## **Great North Road Solar and Biodiversity Park**

Draft Statement of Common Ground with Nottinghamshire County Council

Document reference – EN010162/APP/8.1

December 2025

**Location of Geophysical Survey and Trenching
Figure 11.2a**

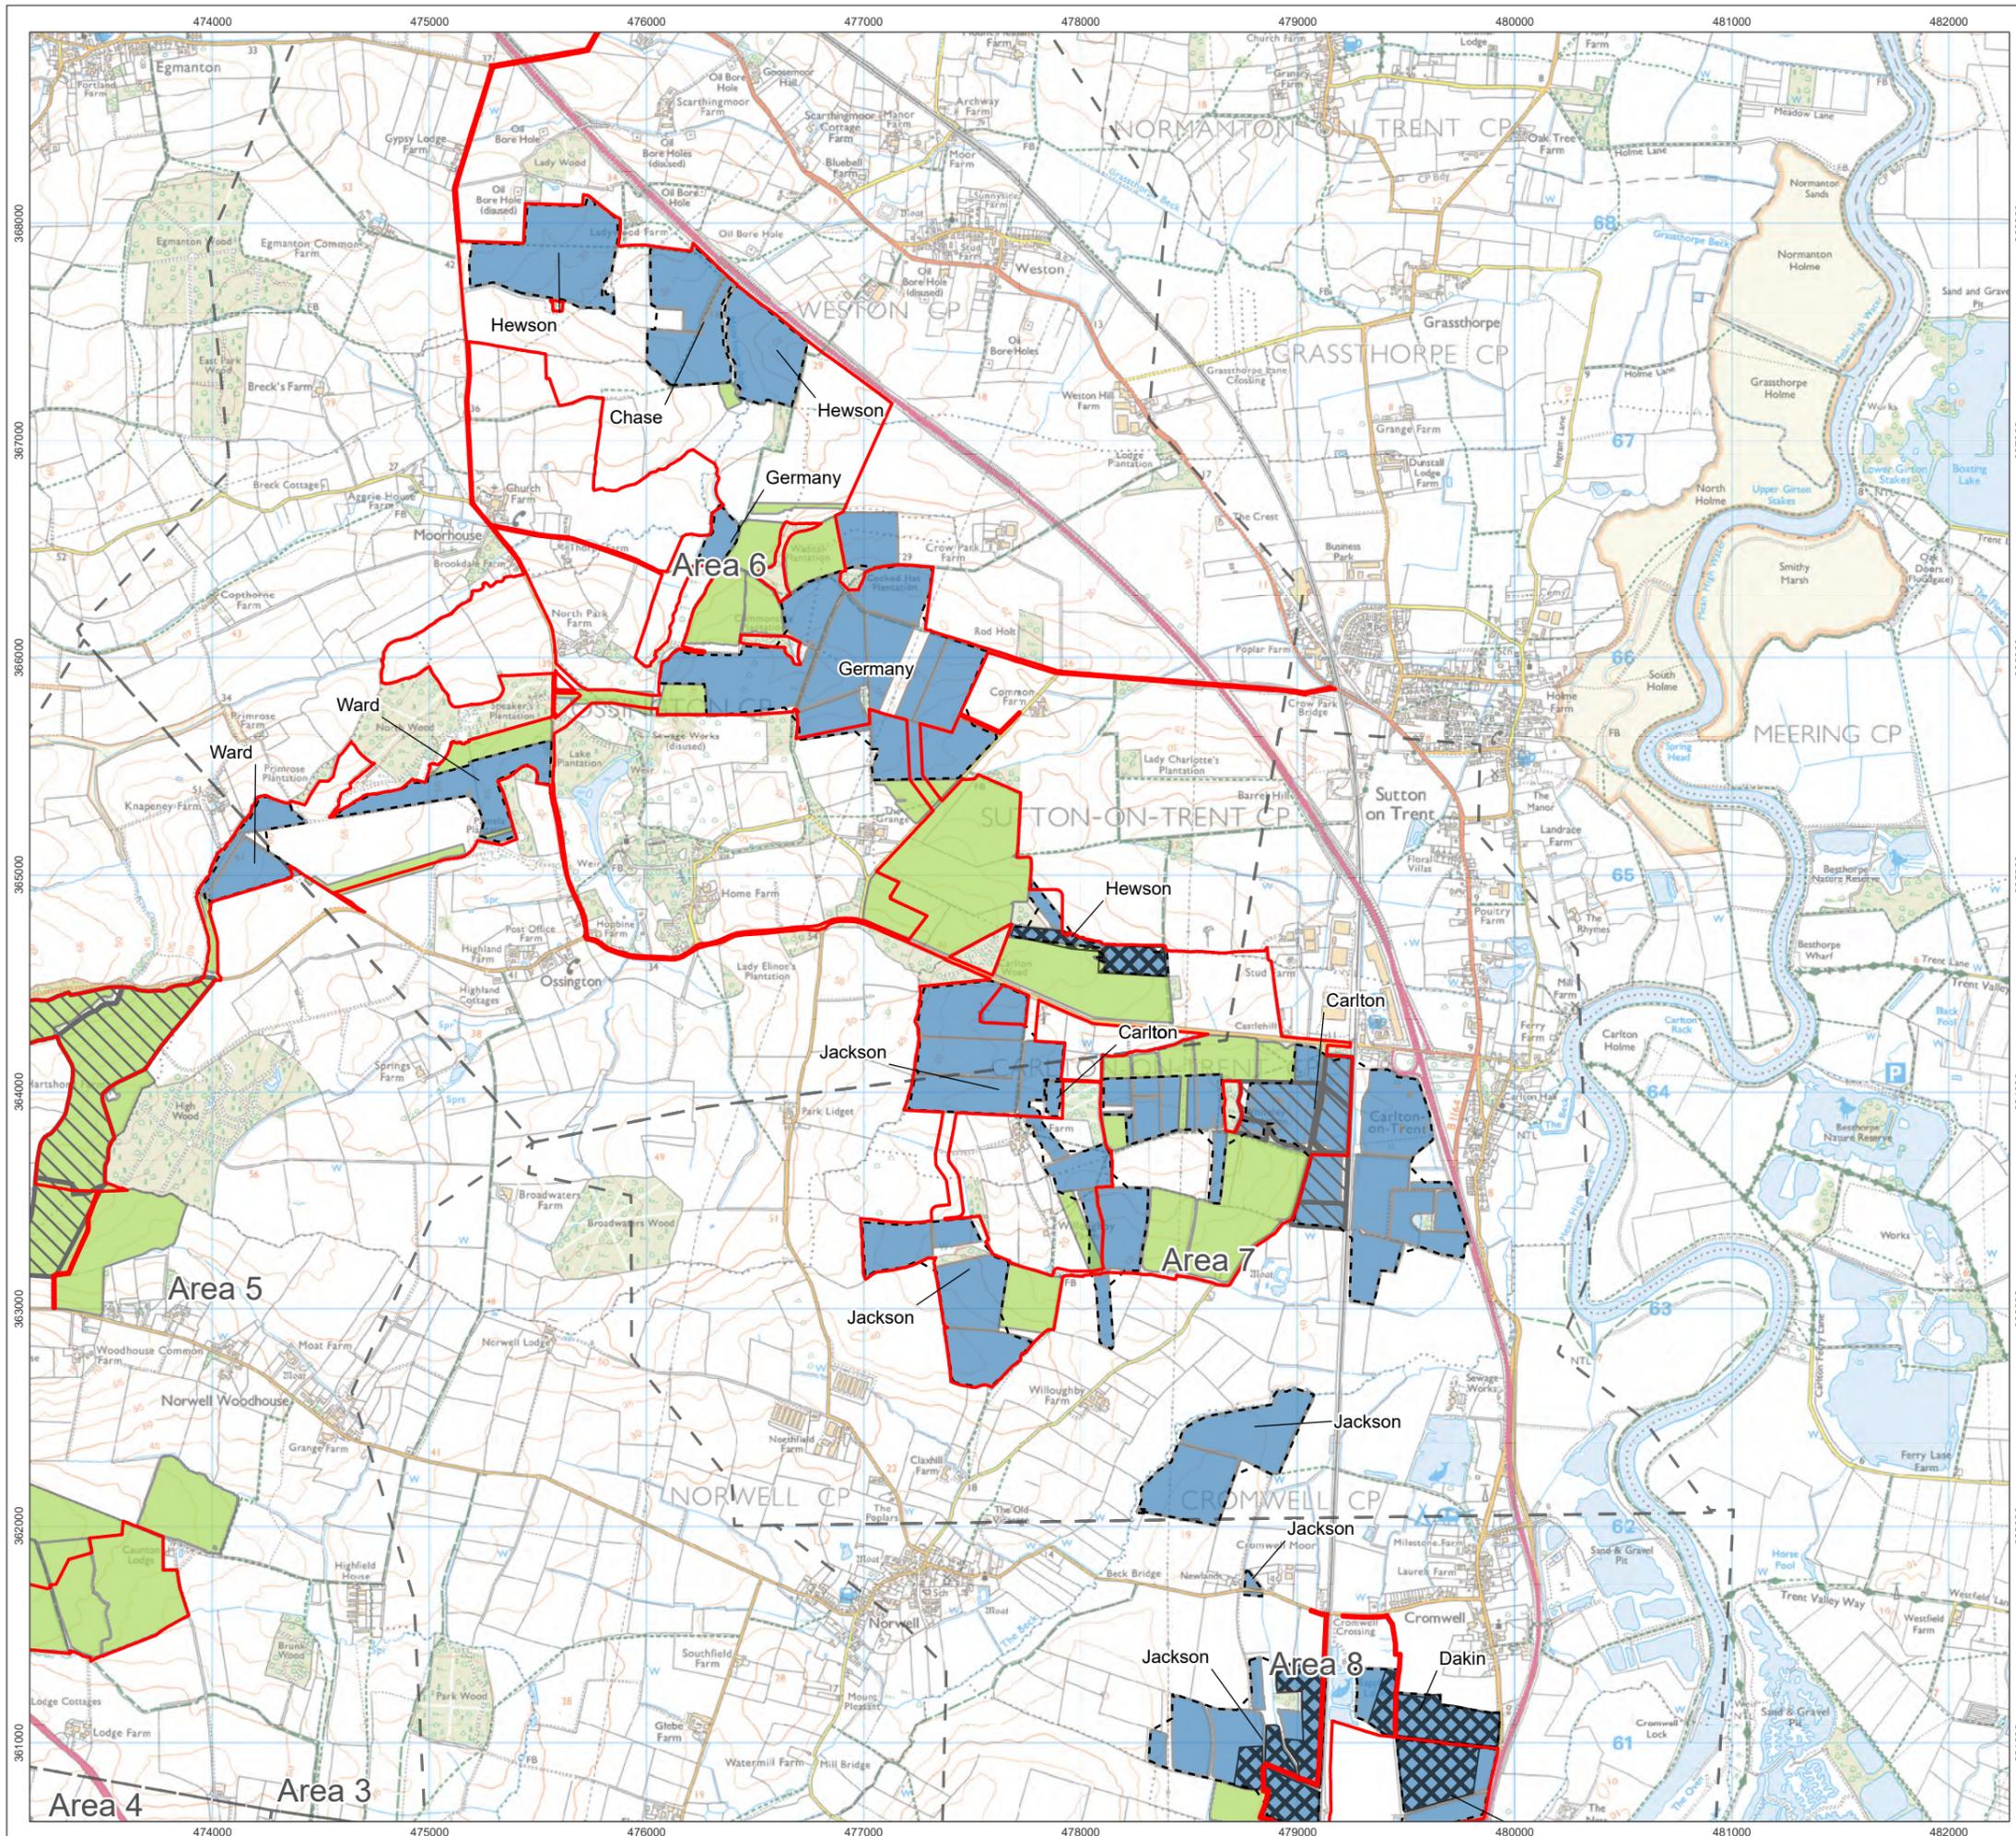
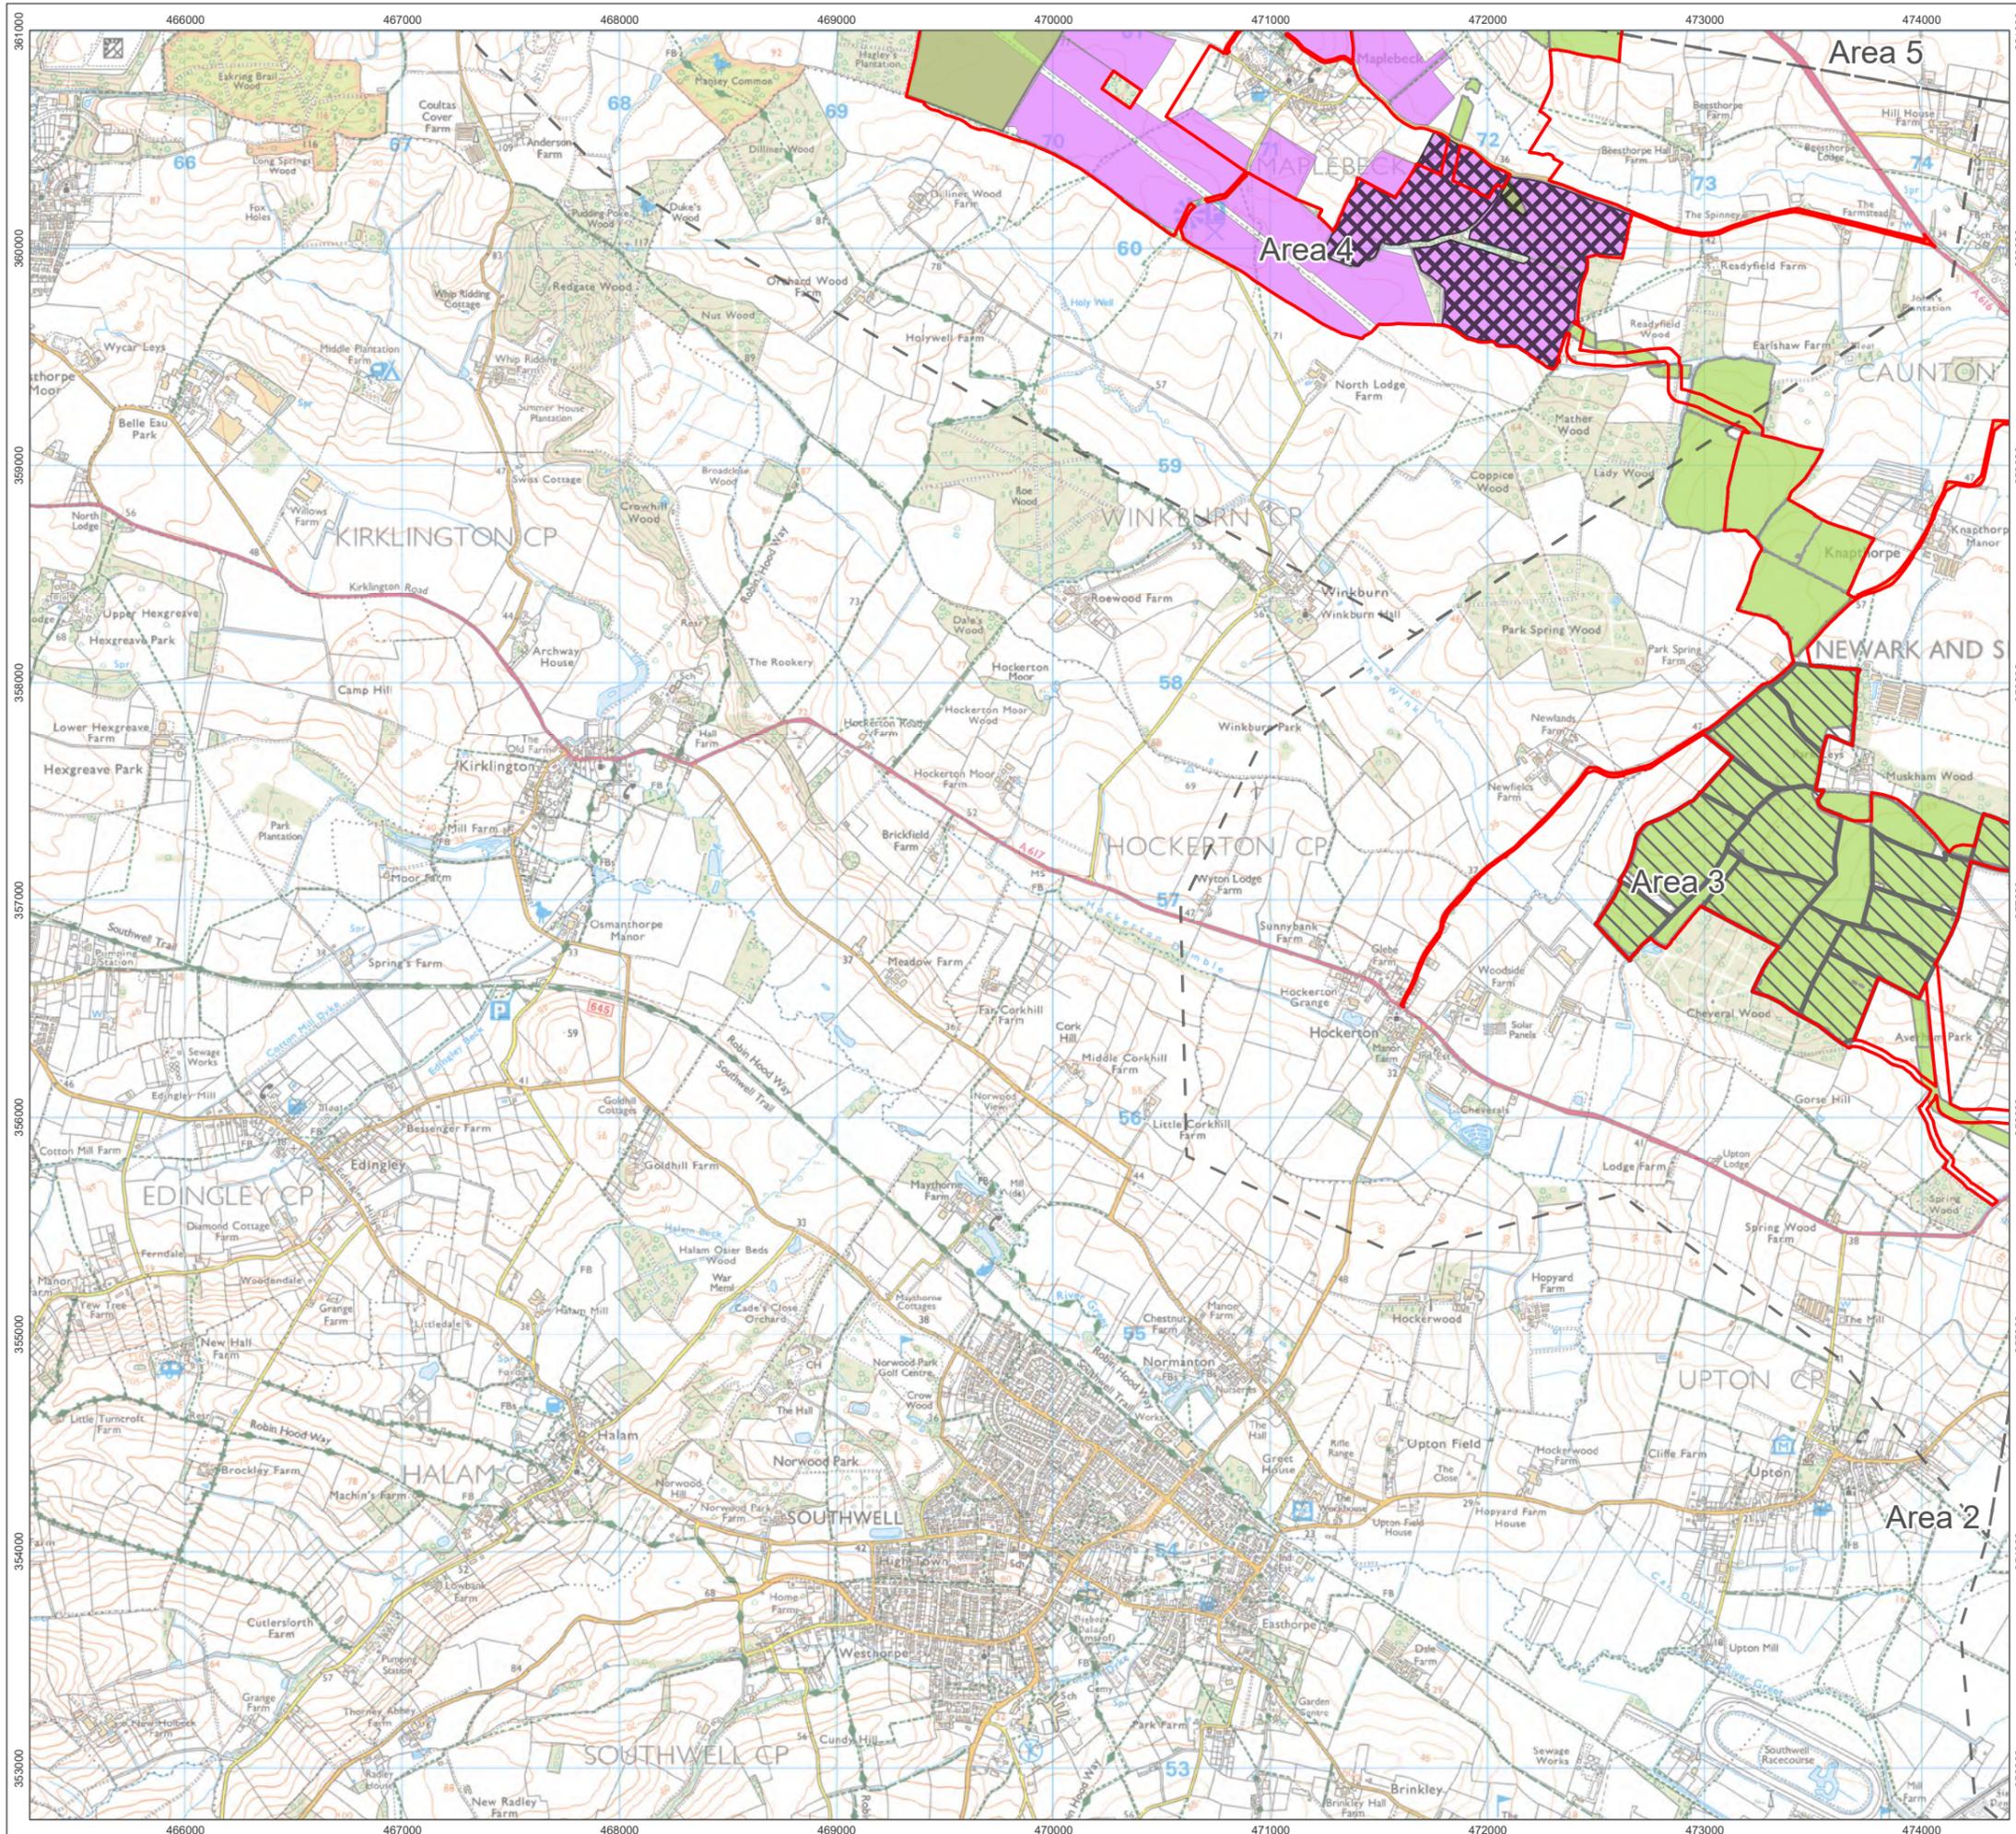
2.2.6	RR	AMS (Trial trenching)	<p>The statement that the archaeological assessment work to date has been largely sufficient to provide an acceptable level of data to inform the ES is welcomed.</p> <p>In regard to the completeness of survey to date it should be noted that geophysical baseline survey coverage was c.90% and that trenching tested all geologies. This is considered to be proportionate, in line with developing best practice guidelines and sufficient to inform the ES.</p>	We welcome the archaeological assessment work undertaken to date and broadly welcome the approach undertaken by the applicant. The desk-based assessment covers the full site and the geophysical survey has been undertaken on the majority of the order limits. This has been largely sufficient to provide an acceptable level of data to inform the baseline for the Environmental Statement (ES) and an initial phase(s) of trial trench evaluation.	Under Discussion

Ref	Relevant Documents	Description of Matter	Applicant's Position	NCC's Position	Status
			<p>The scope of post-consent investigation, provision for which is set out in the OAMS, will be agreed through continued engagement with NCC during the period of the examination.</p> <p>It is expected that the post-consent investigation and subsequent mitigation will be developed in line with emerging best practice as set out in Archaeology and Solar Farms: Good Practice Guide:</p> <p><i>A toolkit for developers, archaeological advisors, consultants and contractors.</i></p>	<p>However, the applicant acknowledges that the geophysics results have not been tested in their entirety (Para. 48) which we consider a serious limitation when undertaking an appropriate assessment and gathering sufficient data to inform significance and impact.</p> <p>However, the OAMS has made provision for post consent geophysics and trial trench evaluation work that will potentially resolve the above issue if implemented appropriately. The OAMS has left the scope of this work to be agreed.</p> <p>We appreciate that solar farm development differs slightly from other development types and that some elements will not be fixed until post consent. While we maintain our position that the assessment work should be completed as part of the application/examination process to inform design, we</p>

Ref	Relevant Documents	Description of Matter	Applicant's Position	NCC's Position	Status
				<p>accept that some evaluation work could be left until the detailed design has been fixed and when areas of higher impact can be properly targeted for intrusive evaluation. For instance, panel arrays may have a relatively low impact if cables are clipped up behind rather than buried in trenches behind, and details on this will help influence the level of intrusive evaluation required to characterise the archaeology and assess impact.</p> <p>During the examination period, we would expect to further refine the OAMS in consultation with the applicant and their consultants and agree an outline programme for the post-consent completion of the assessment work. There will also need to be specific wording included in the DCO with respect to the archaeology requirement which secures completion of the assessment work and provision for an</p>

Ref	Relevant Documents	Description of Matter	Applicant's Position	NCC's Position	Status
				<p>updated AMS and its timely implementation prior to any construction work being undertaken.</p> <p>We are confident that these issues can be resolved with the applicant and their consultant if they continue to engage with us by the end of examination.</p>

**2.2.1 Applicant Response:** For background and context, EN-3 confirms that appropriate desk-based assessment, and where necessary, a field evaluation, in consultation with the local planning authority, should identify archaeological study areas and propose appropriate schemes of investigation, and design measures, to ensure the protection of relevant heritage assets (paragraph 2.10.113).

- 2.2.5 The Applicant completed a desk-based assessment and a full geophysical survey was undertaken covering the areas where physical development is proposed within the Order limits to establish a baseline understanding of the potential for sub-surface archaeology. The Applicant recognised and responded to comments raised by the County Archaeologist. To mitigate this the Applicant has included flexibility in the Works Plans to relocate Development elements and/or utilise non-invasive installation methods (ballast) to avoid any impact on sub-surface archaeology.

- 2.2.6 In addition, the Applicant has completed a number of targeted trenches and boreholes, which have been discussed and agreed with the County Archaeologist. These have been targeted to the areas of greatest archaeological potential identified during the desk-based assessment and geophysical survey and also where the geophysical survey had interpreted discoveries as being of likely geological origin rather than archaeological interest and in areas where there was no specific intelligence to suggest archaeology, but to test the quality of the geophysical survey. The quantity of evaluation trenching is considered to be proportionate at this stage and further evaluation will take place post-consent as detailed in the **Outline AMS (TA A11.8 [EN010162/APP/6.4.11.8]) [APP-269]** (see Section 11.7).
